From: Michael Eastham
Sent: 13 June 2018 11:49
To: Planning.Responses
Subject: FW: The Lillies, Yapton Road, Barnham

From: Sue Howell
Sent: 31 May 2018 18:09
To: Michael Eastham
Subject: RE: The Lillies, Yapton Road, Barnham

Sketch Layout - 01

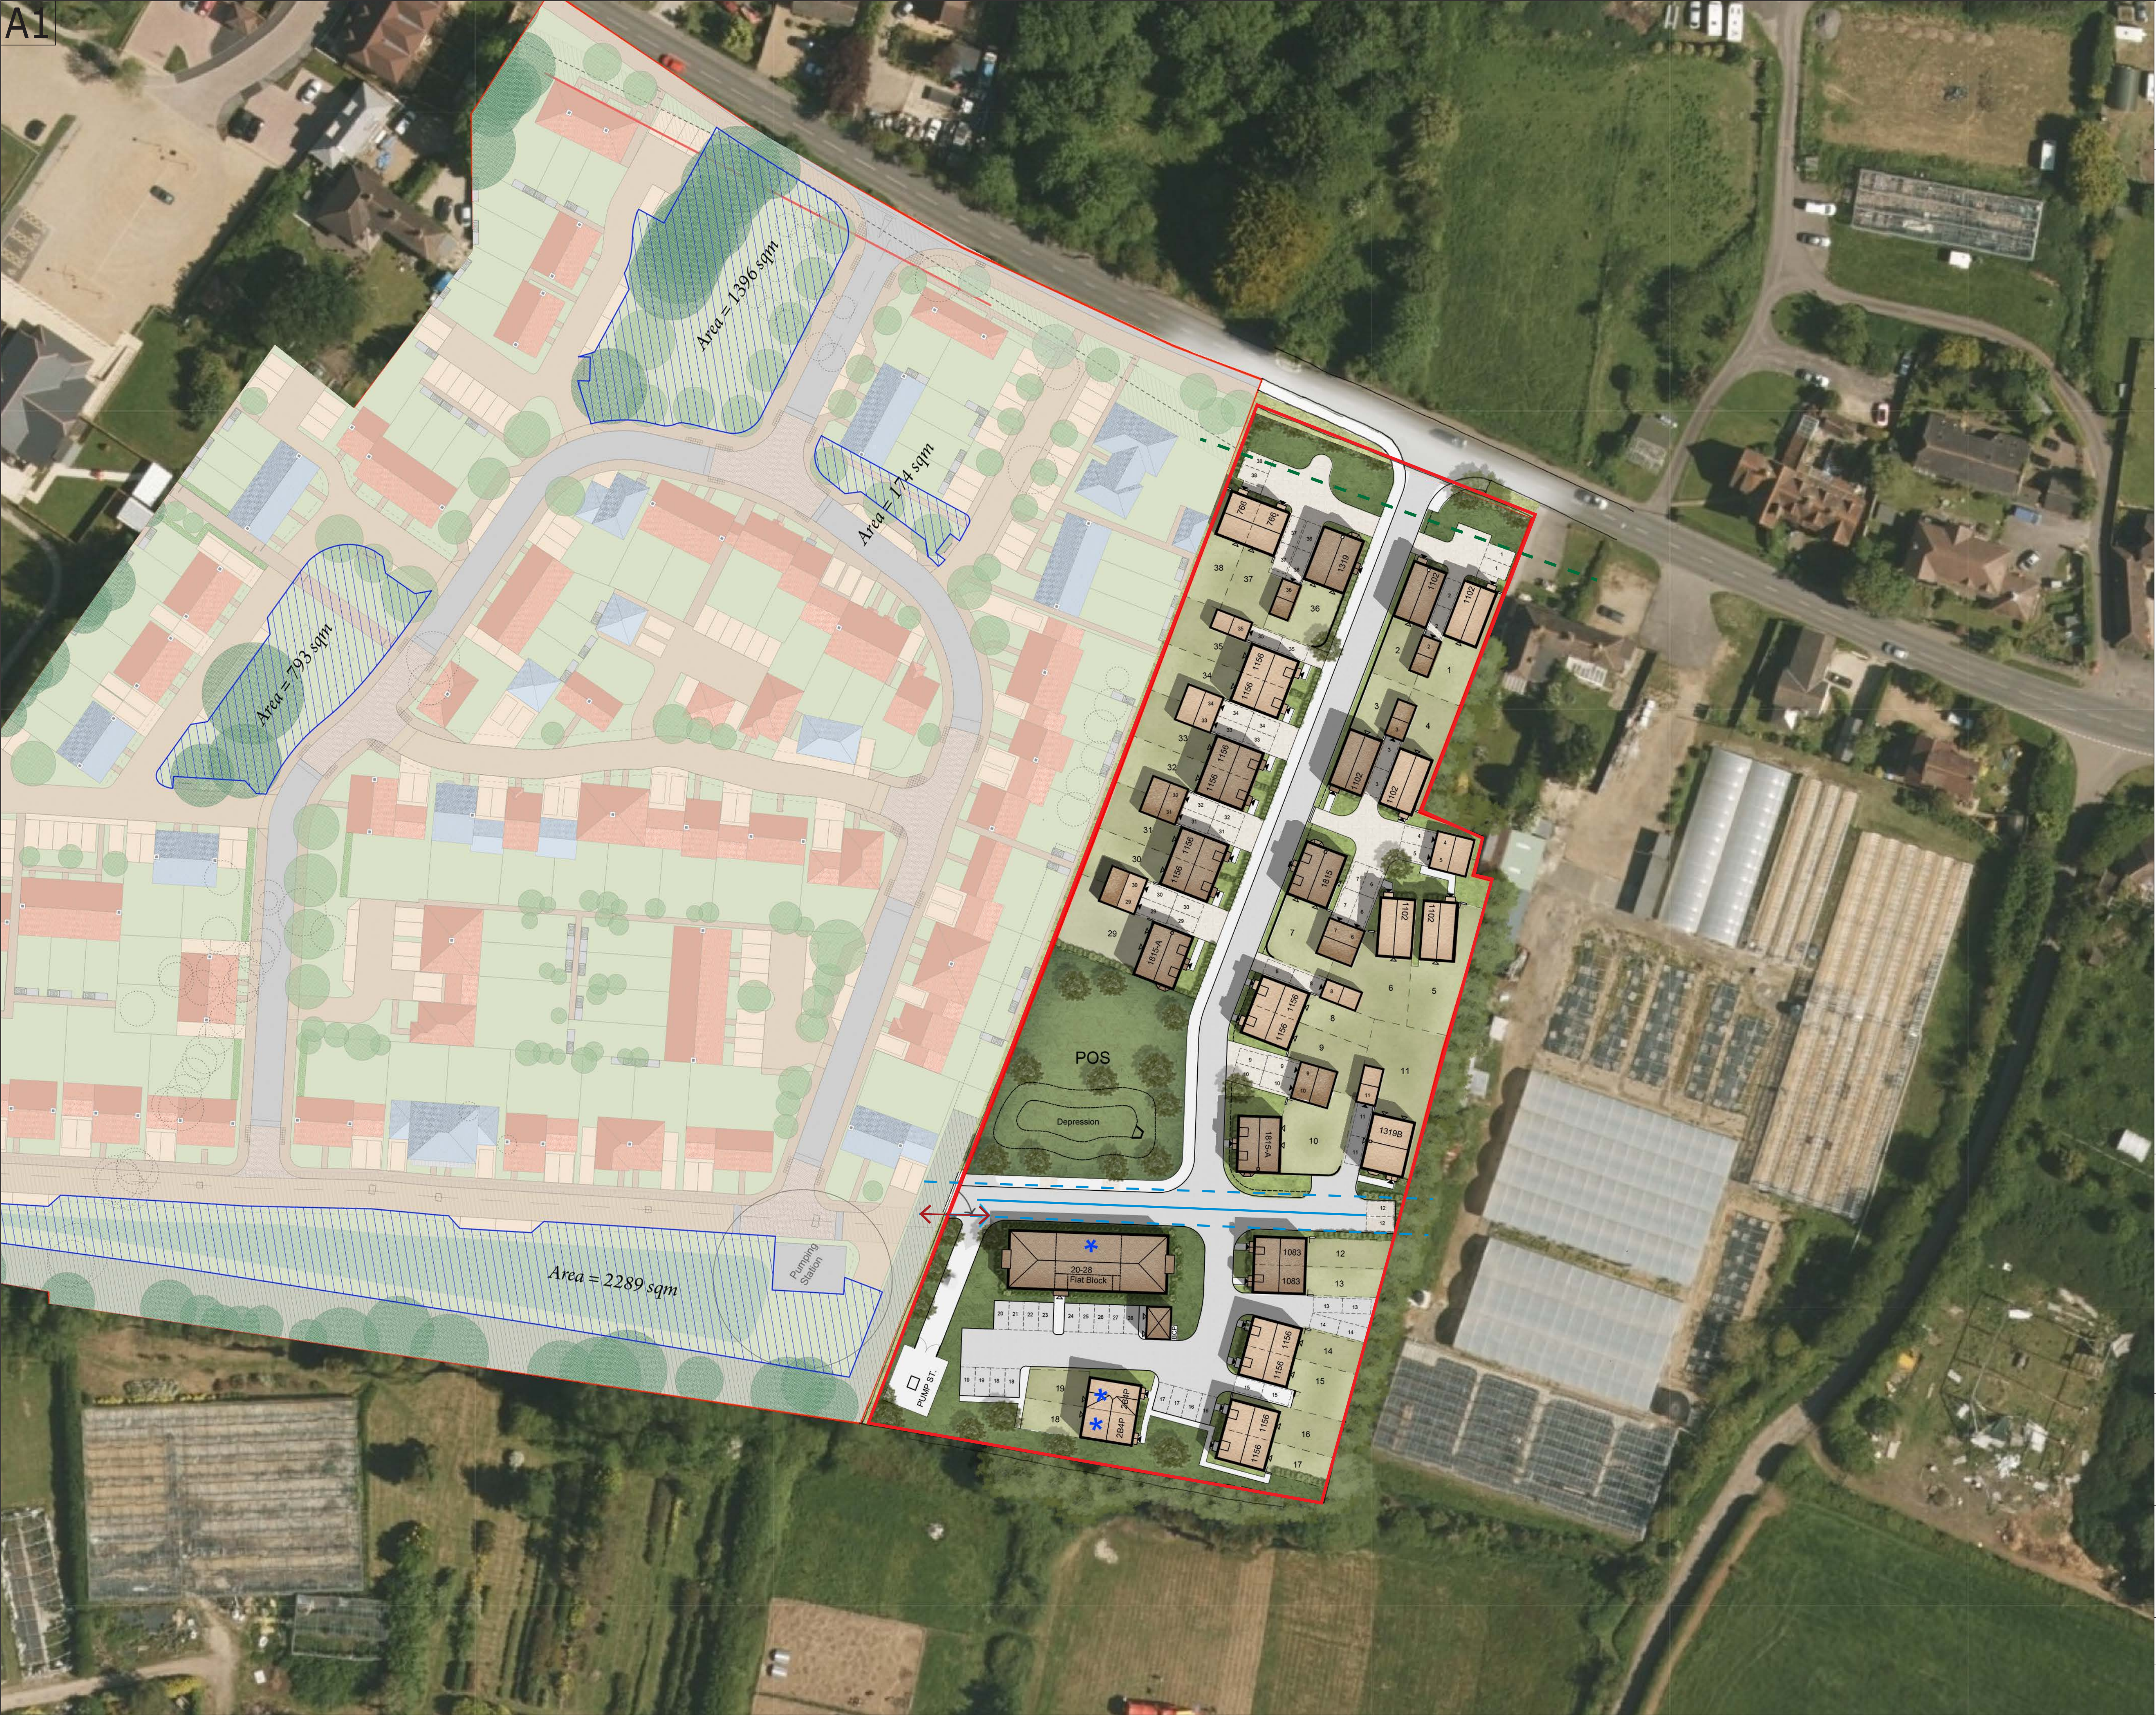
In response to the latest revised layout for Lillies, I am encouraged that thought has been given to placing the POS back more centrally within the development and that the SuDS is now not taking the large proportion of this as previously shown.

I am however not so convinced by the positioning of the SuDS in such close proximity to the block building 18-26 and also now seemingly tucked away in a corner and not integrated in a beneficial way with the surrounding site.

My conclusion is that the incorporation of sufficient area of POS and SuDS area within this proposed development continues to not be the subject of 'good design' and that both appear to be being treated as an unnecessary inconvenience. The bottom line with this and any development is that we should be striving for the best quality design, creating desirable places for people to live, which I still maintain is not being realised here.
